Re: Foundation Observation
Lot 1147 ACC
245 Education Drive
Springs Lake, NC 28390
D.O.I.: April 29, 2021

On April 29, 2021, Chicora, PLLC performed a site review requested by the client Floyd Properties to observe a void in the proposed foundation footing. Please see the attached drawing for an approximate location of the area observed.

PLOT PLAN

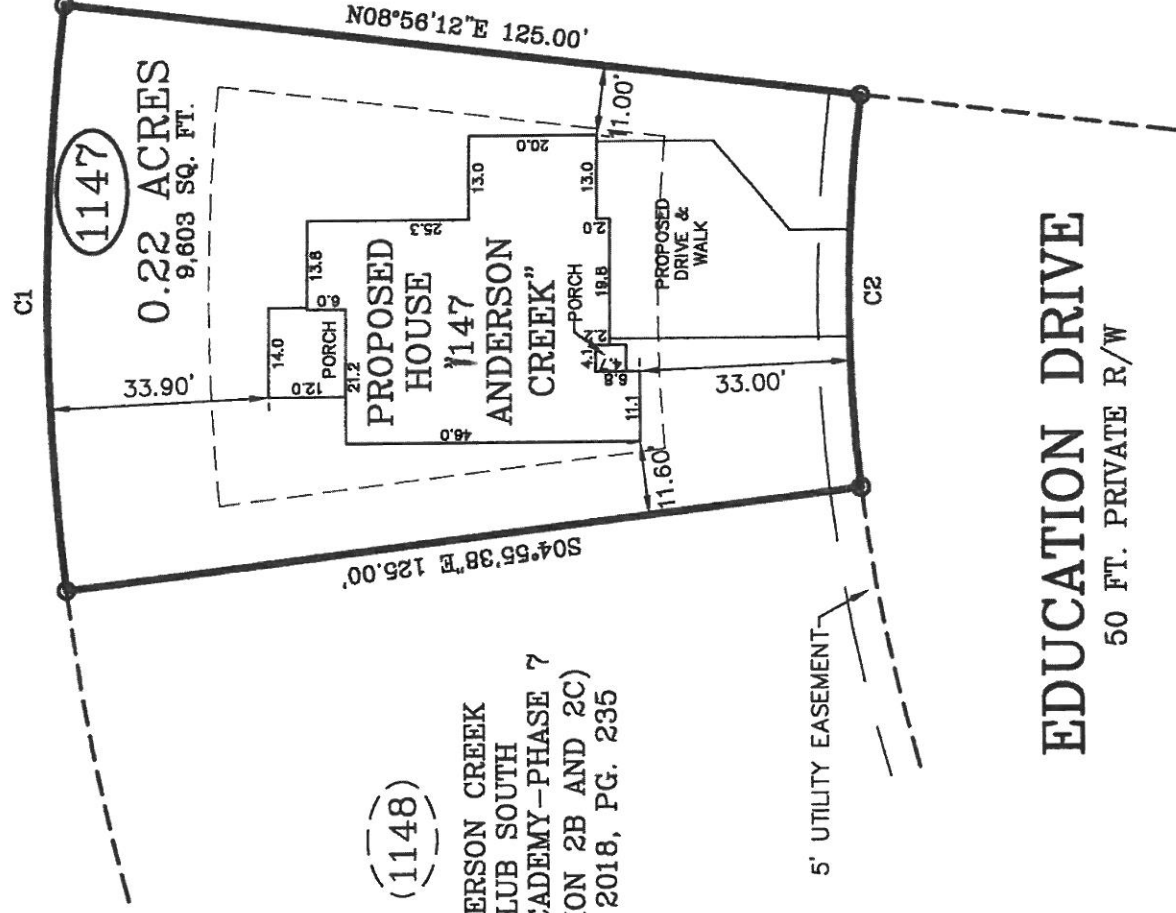
Chicora, PLLC meet with the foundation subcontractor on site and observed the area. The area was identified as a location where a tree stump was removed during the footing excavation. Chicora, PLLC probed the area with a probe rod to verify the soil stability.

Chicora, PLLC recommends to excavate the area by 2ft (length) x 2ft (width) x 2ft (depth) and place concrete in the area during the placement of concrete for the footings.
